The Coal
Authority

10th March 2026

Re: Planning application 2026/0160

Erection of a mixed use barn at first floor level above the existing silage clamps, part-educational use (Class F1) and part-leisure use (Class E) at Cannon Hall Open Farm, Bark House Lane, Cawthorne, Barnsley, S75 4AT

South West Elevation
Scale 1:100

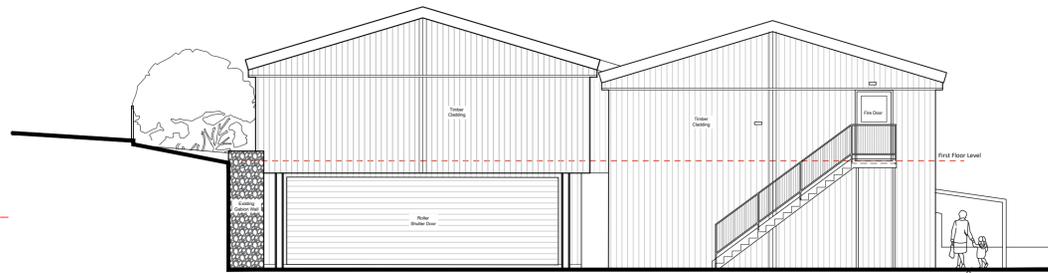
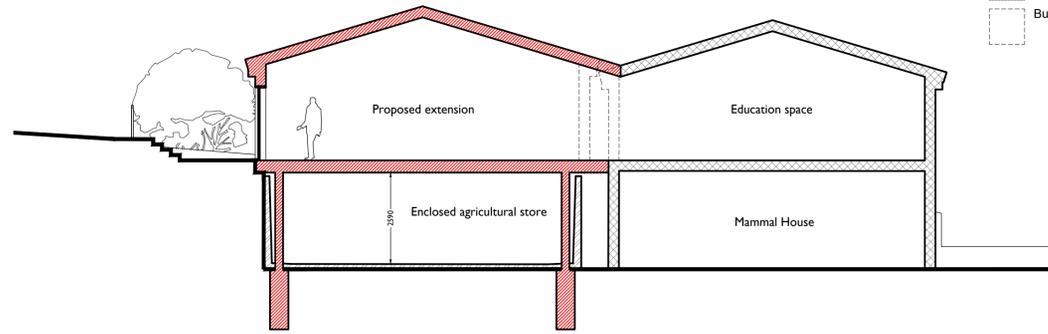
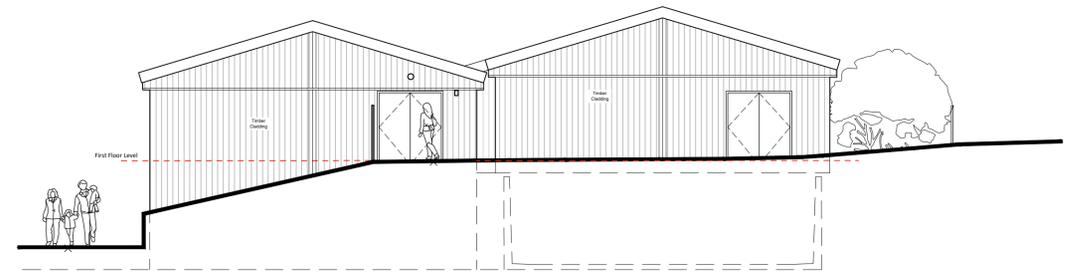
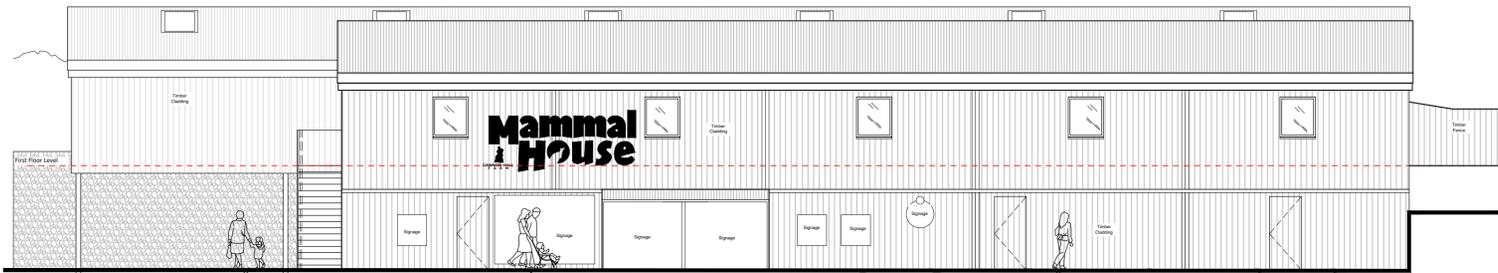
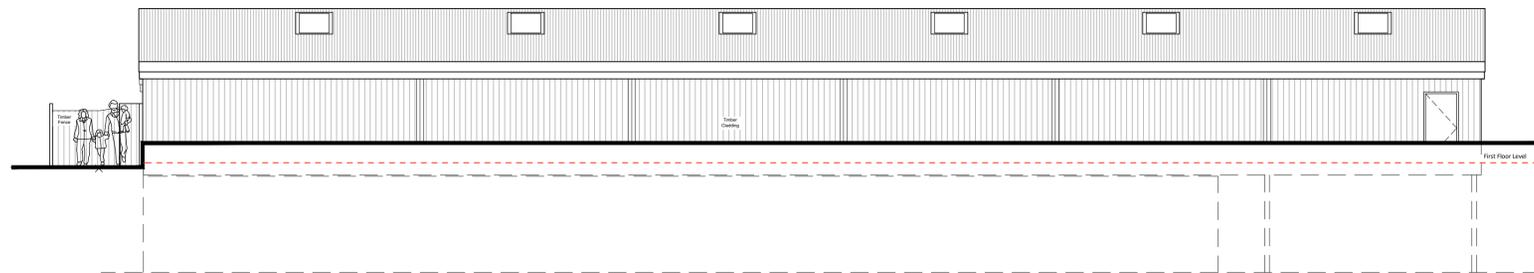
We note that the mixed-use barn will be constructed largely over the existing silage clamps however, it appears that the silage clamp itself will not be used as a foundation and that significant new foundations are proposed. Please revert back to us if our matter on the understanding is incorrect.

Therefore, taking into account the above, in accordance with the agreed risk-based approach to development management in the defined Development High Risk Areas, the applicant should be informed that they need to submit a Coal Mining Risk Assessment to support their planning application. As no relevant information has been submitted at this time, the Coal Authority's Planning & Development Team **OBJECTS** to this application.
